Your Ref: OWQC22439
Our Ref: EP/41/19/PL
Please ask for:
Mr A Wood

1st May 2019

Loft conversion to existing flat.
128 Sea Road East Preston

Elevations (1:100)

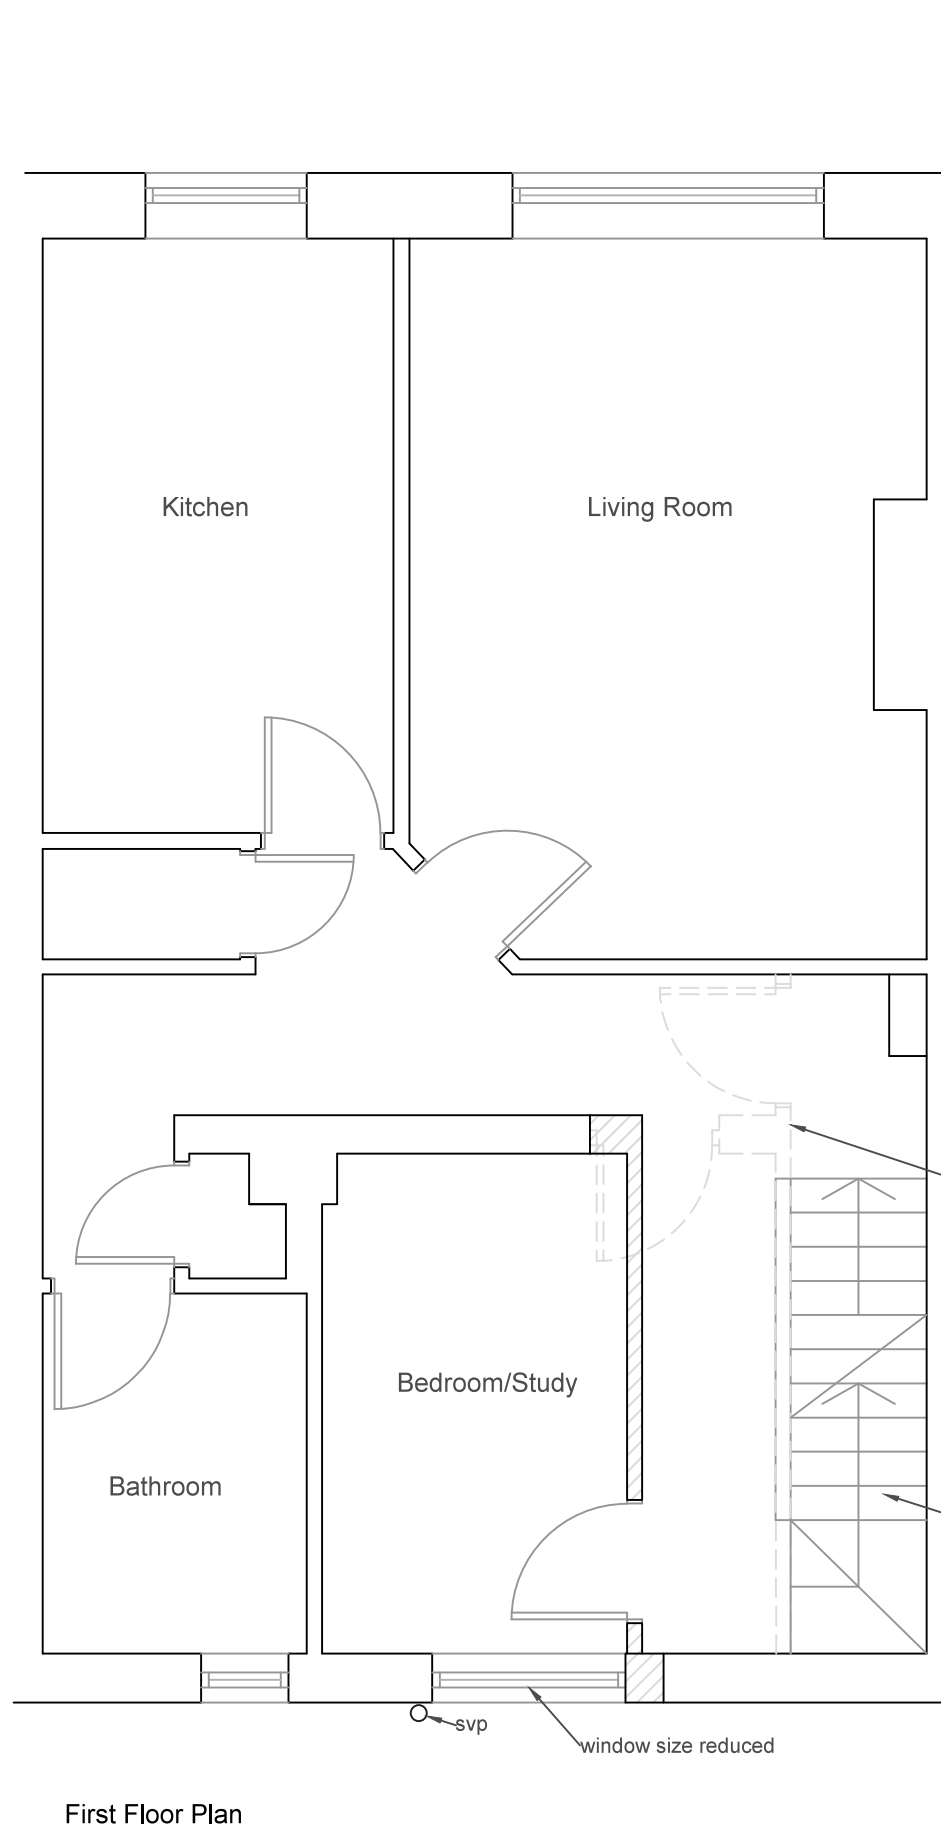
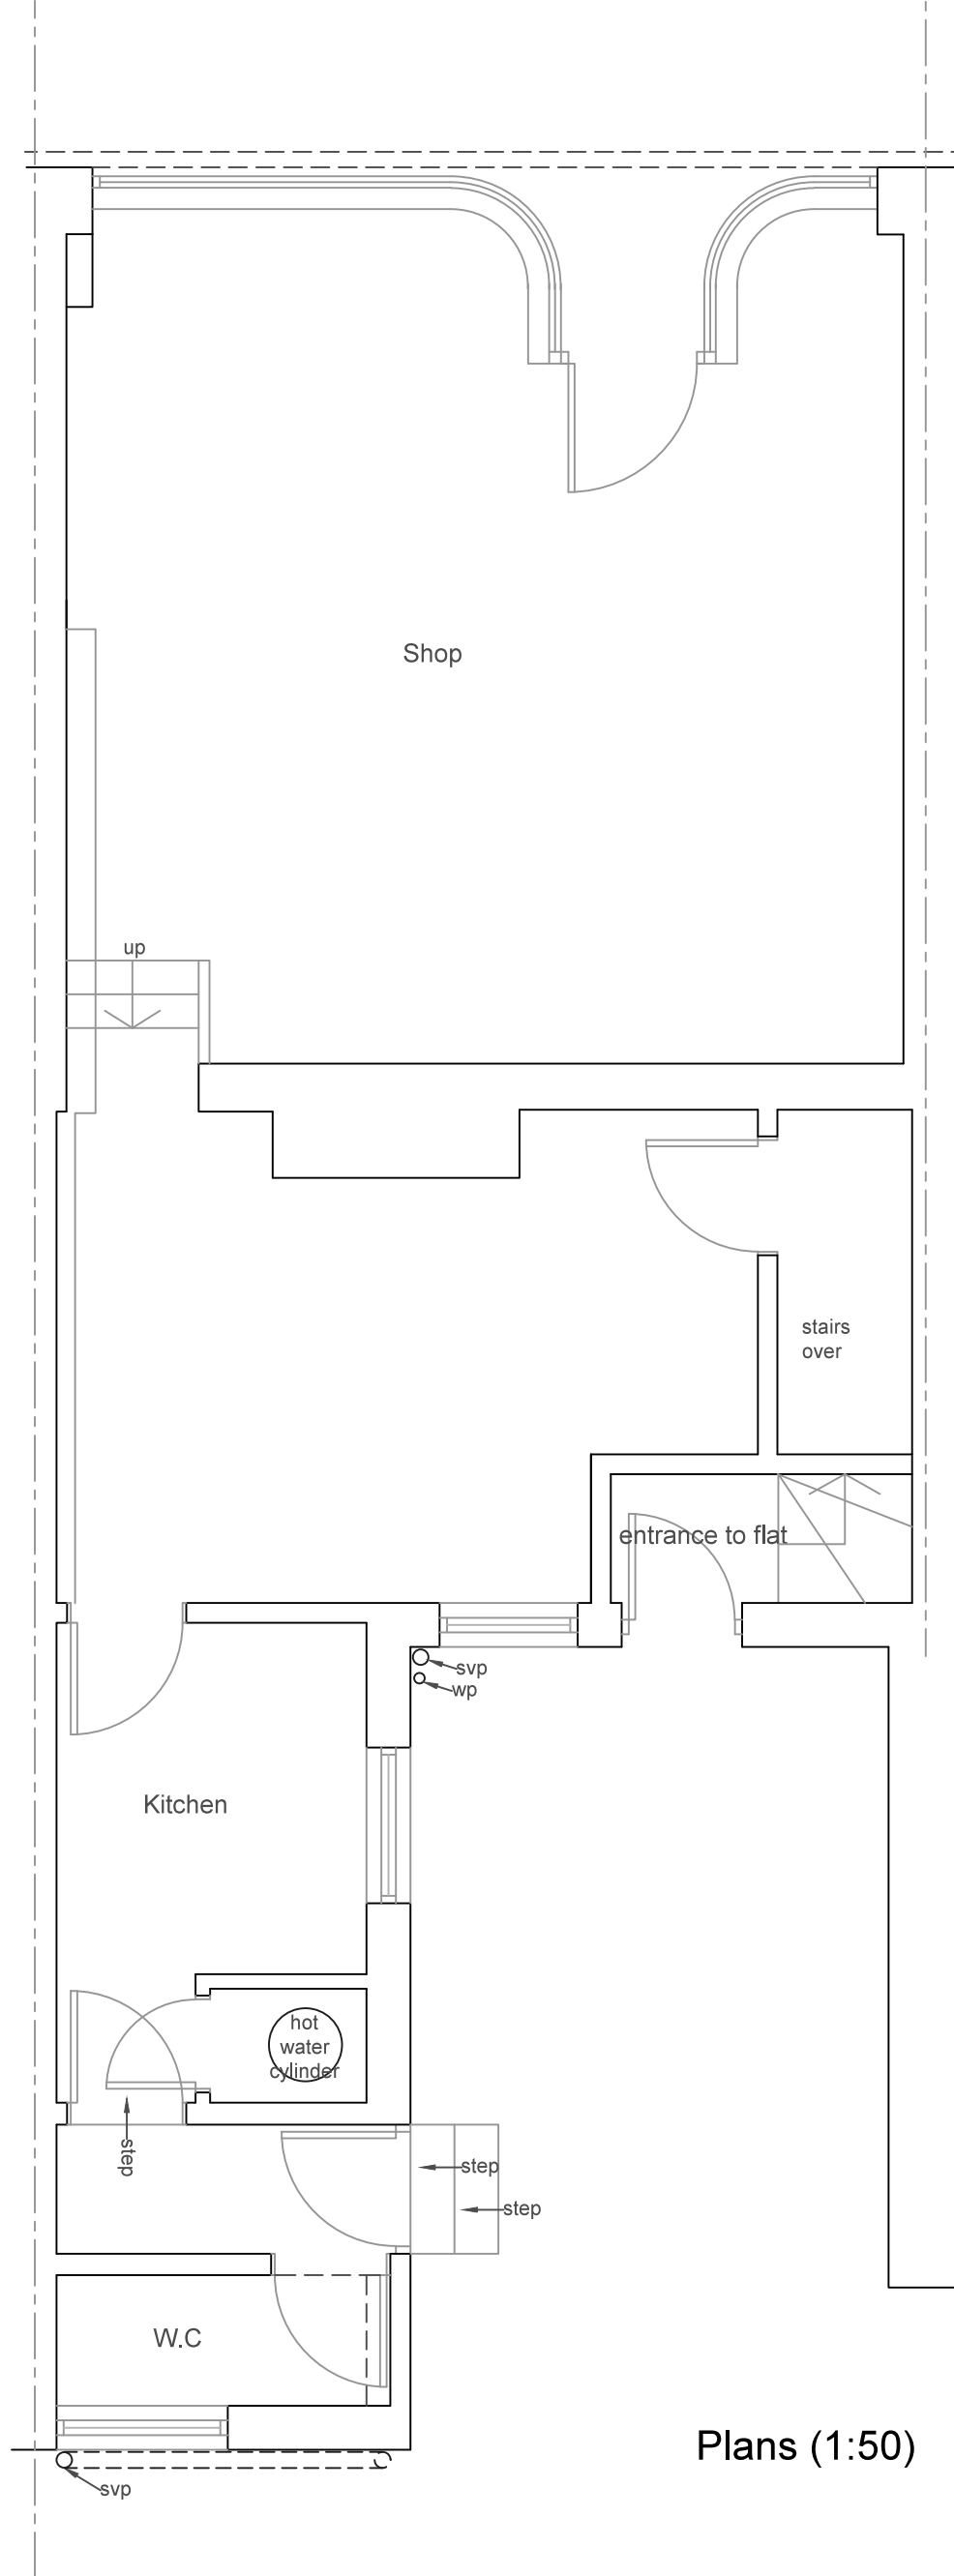
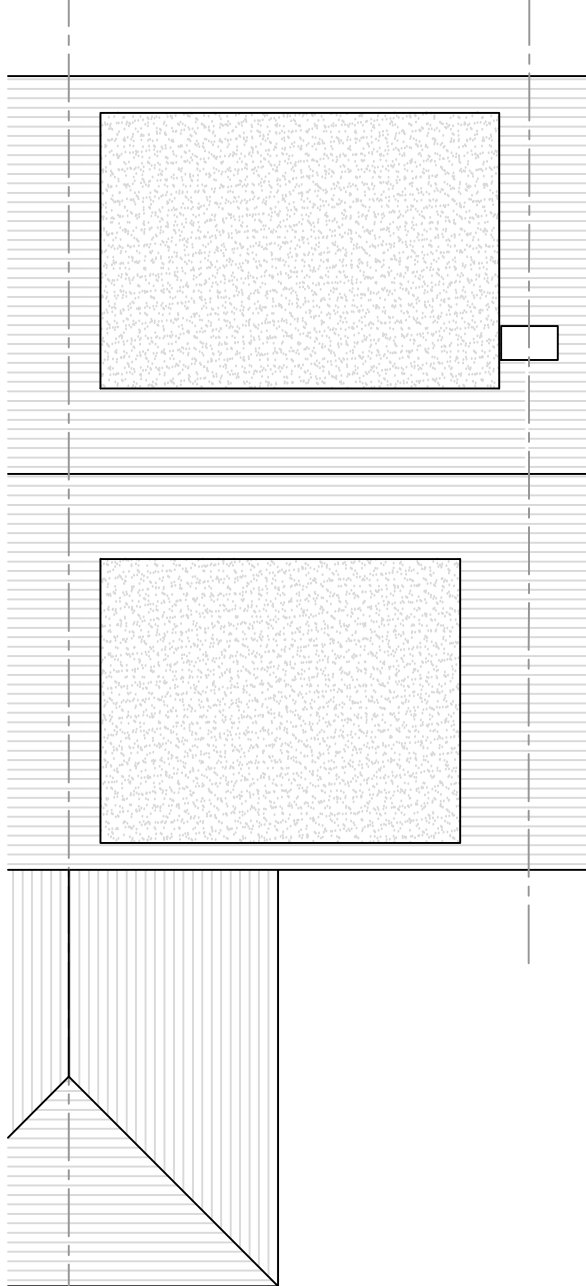
The committee objects to the installation of a front dormer at this property as it will have a negative impact upon this almost unchanged streetscene. This would be contrary to Policy 1 of the East Preston Neighbourhood Plan section 4.18 of which states, Preservation of the street scene is important to protect the character of the village.

The proposed front dormer, by virtue of its design, size and prominent location would have an unacceptable impact upon the character and appearance of the host dwelling and parade of shops as well as that of the immediate locality contrary to policies D DM1 and D DM4 of the Arun Local Plan.

The committee does not object to the proposed dormer to the rear of the property.
